From: Heather Barton
Sent: 17 January 2020 14:35
To: planning
Cc: Environmental Health
Subject: RE: Consultation on planning application 3/2020/0008 The Judge Walmsley Hotel, Whalley Road, Billington BB7 9TP

The application is for a change of use of a public house (use class A4) to children's day nursery (use class D1)

## PROPOSED SITE PLAN

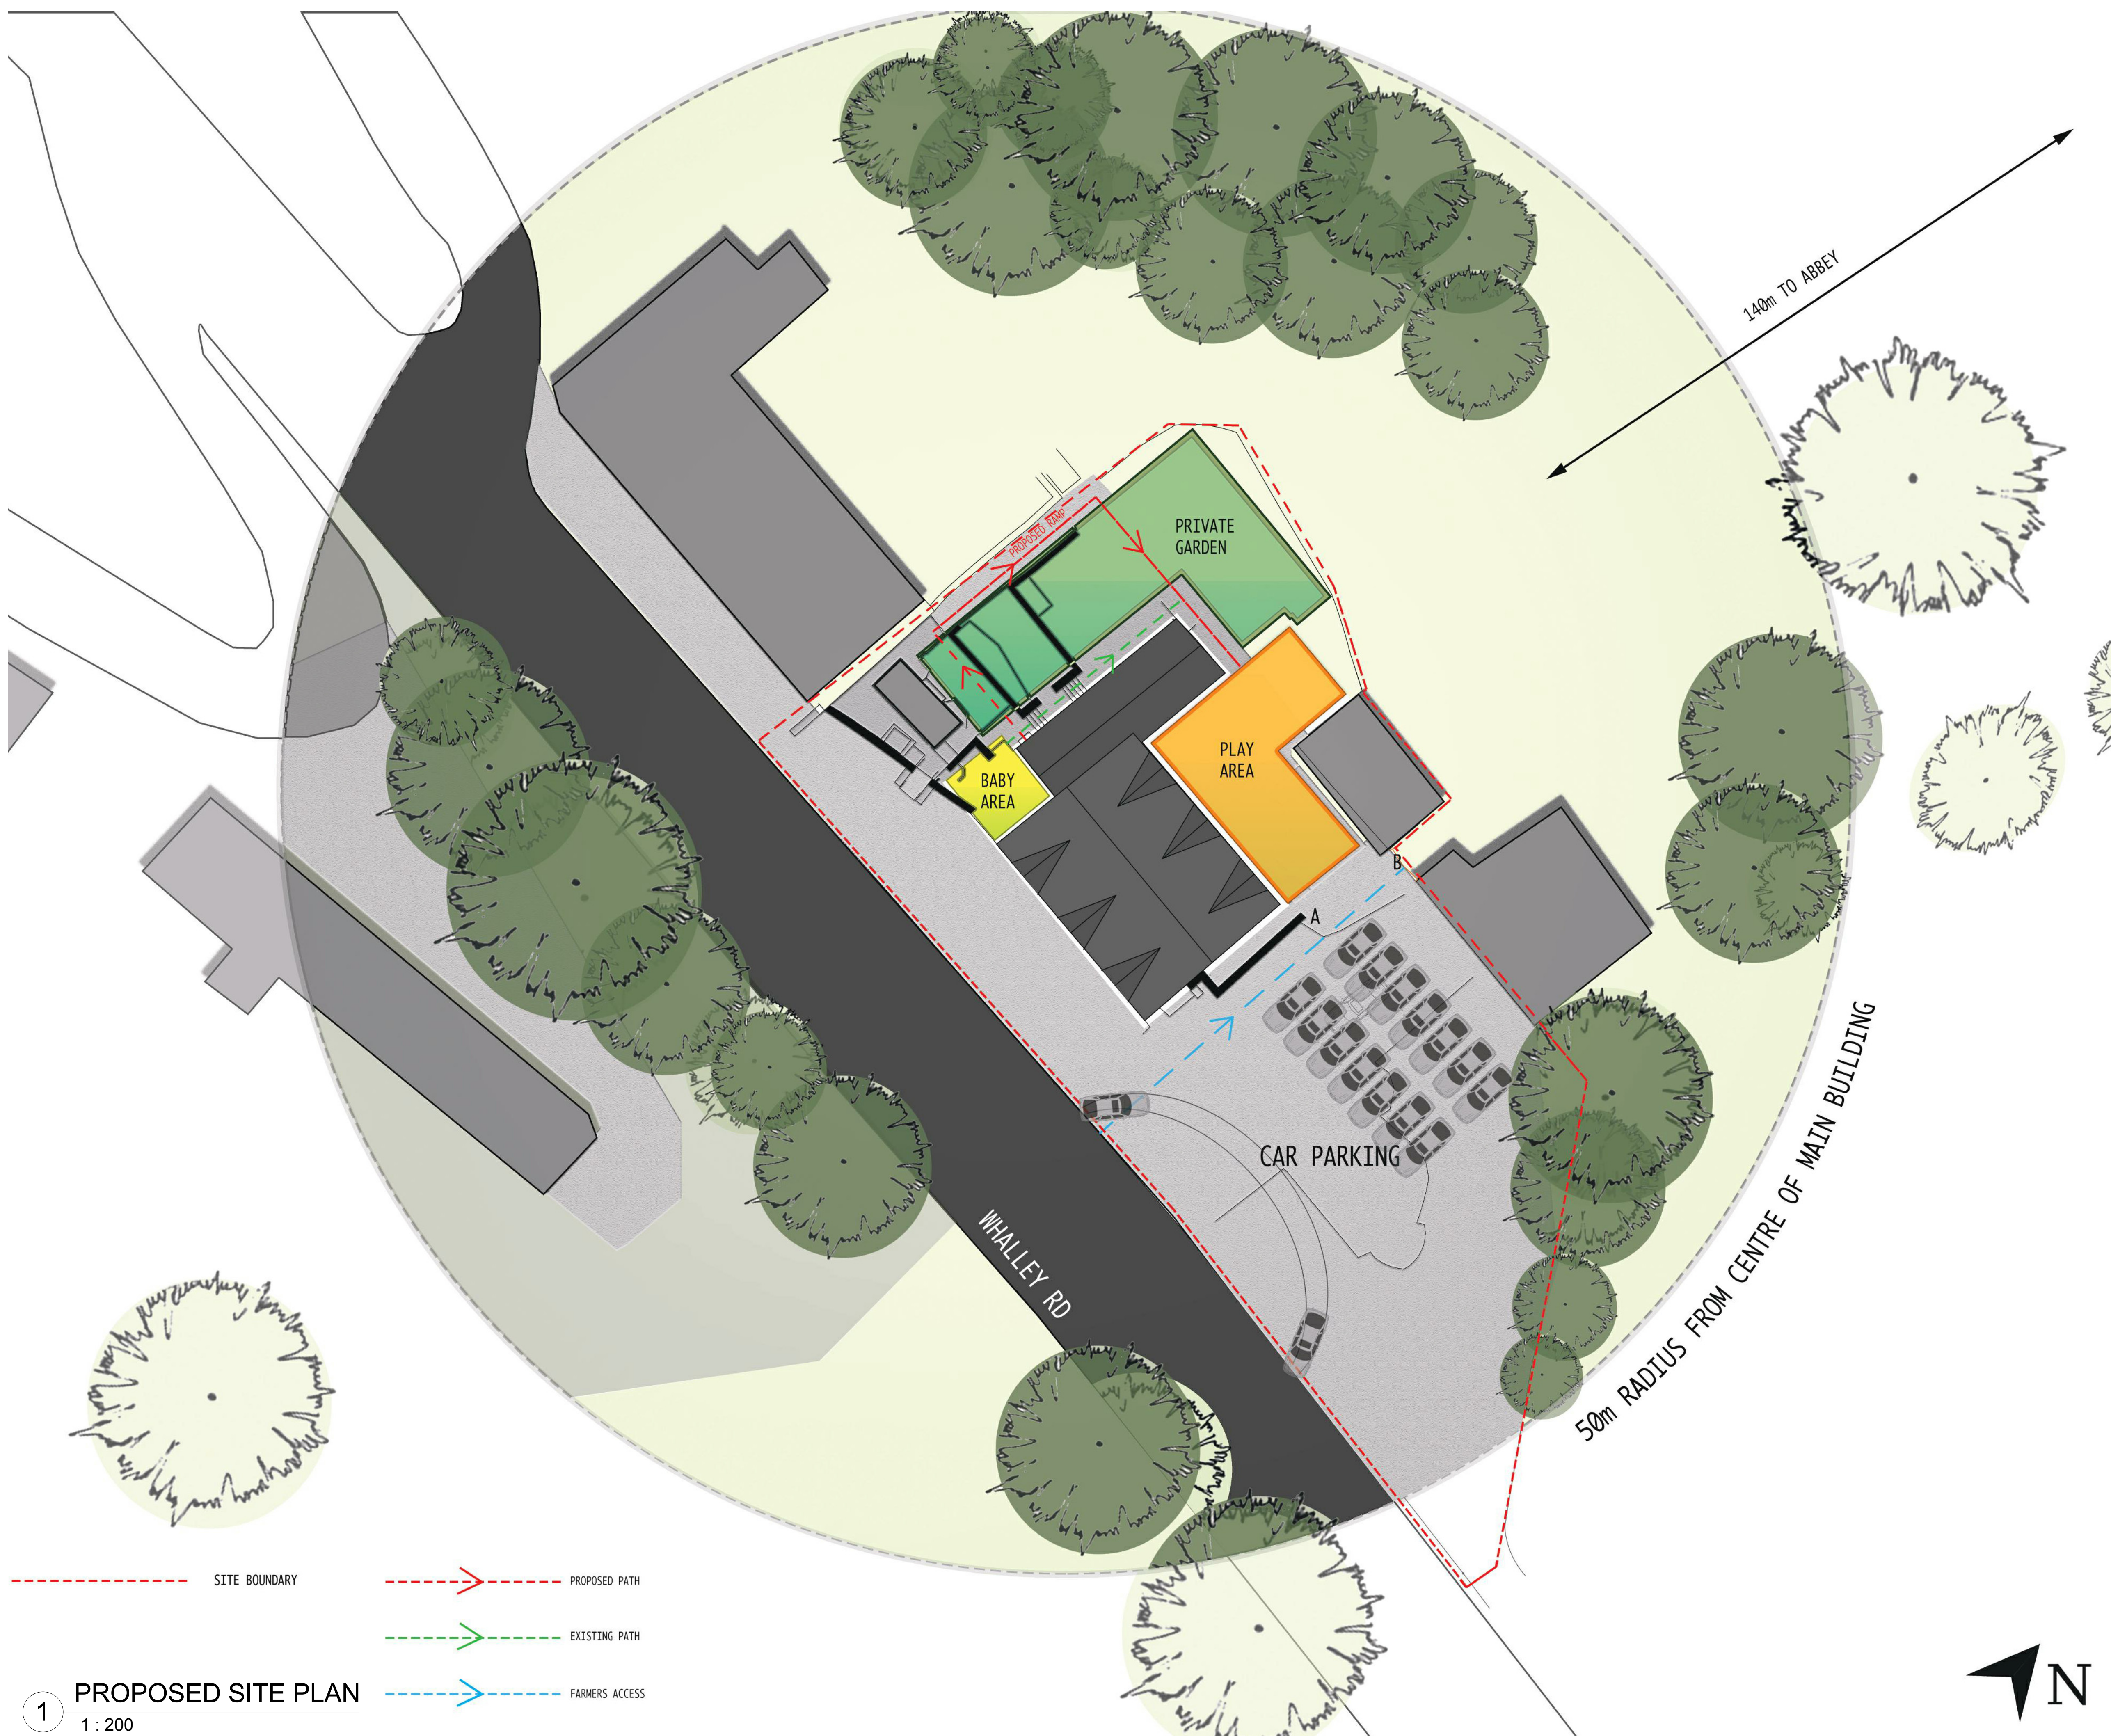
Environmental Health have considered the application and request further details with regards to the use of the external areas i.e. approx. times and length of use within the areas to establish the full impact that the application would have on the neighbouring property .
